Rezoning Petition Review

Rezoning Petition #: 08-119

Location of Property: Approximately 1.63 acres located on the southeast corner of S. Mint Street and Lincoln Street

ILLUSTRATIVE SITE PLAN

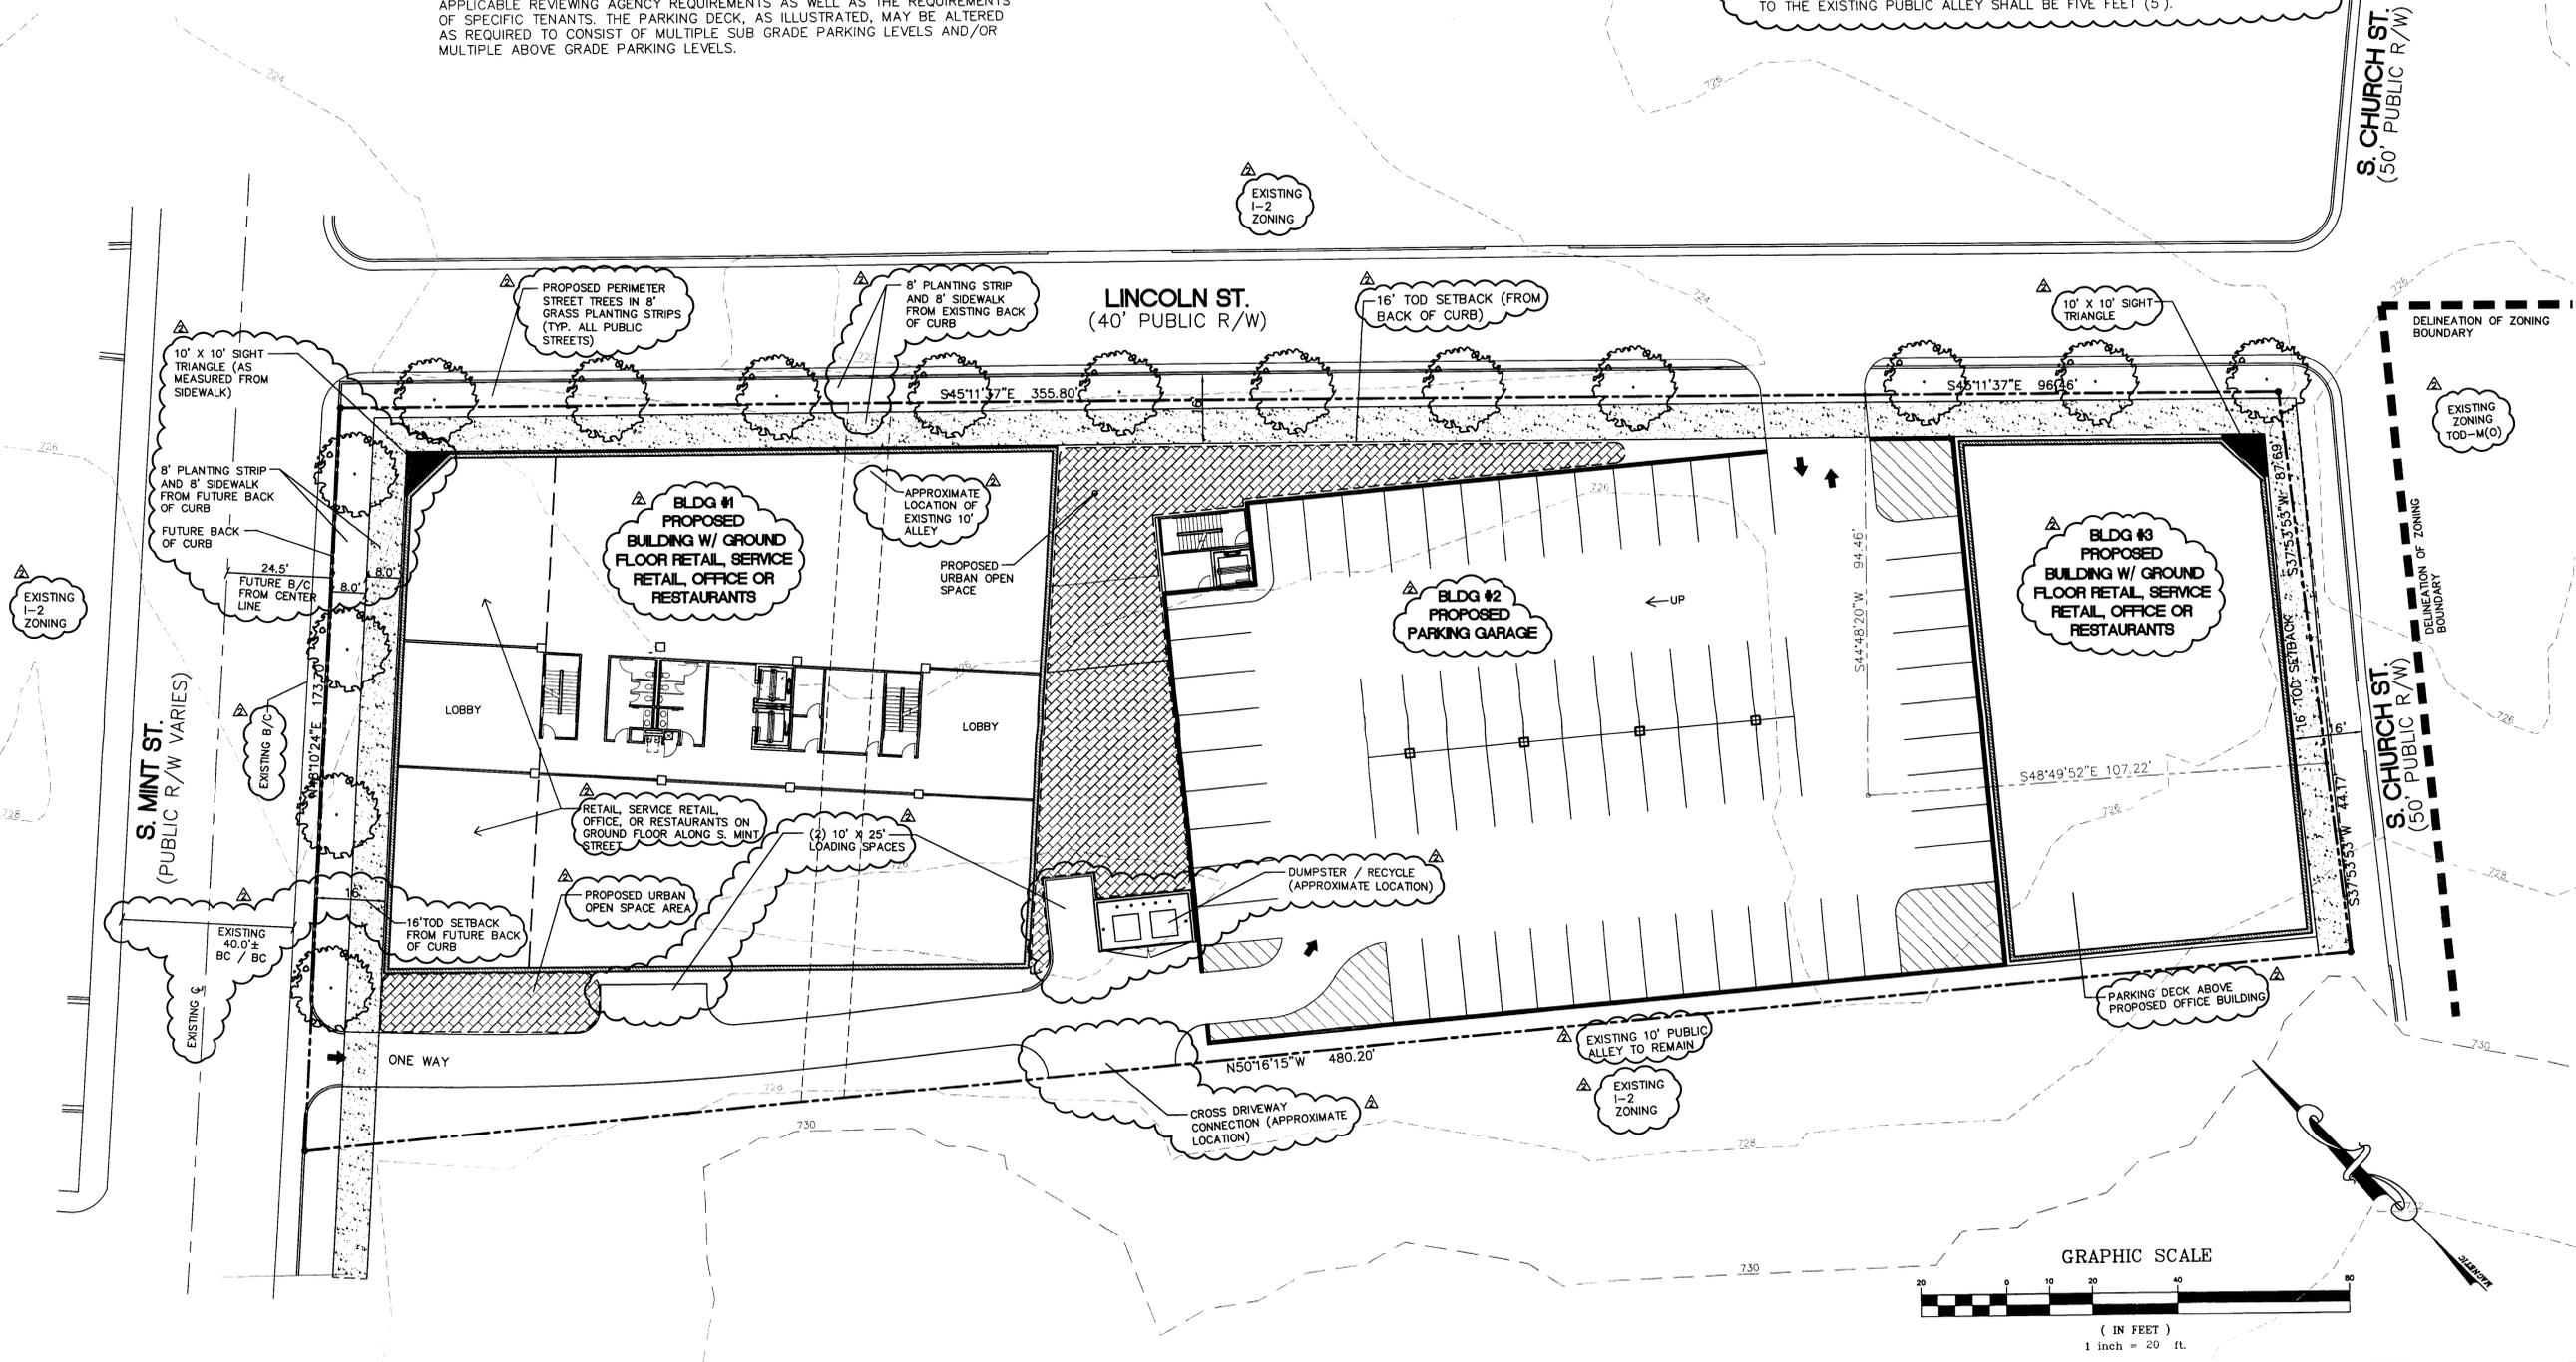
Concerning Storm Water: **Add the following note**

The petitioner shall comply with the Charlotte City Council approved and adopted Post Construction Controls Ordinance.
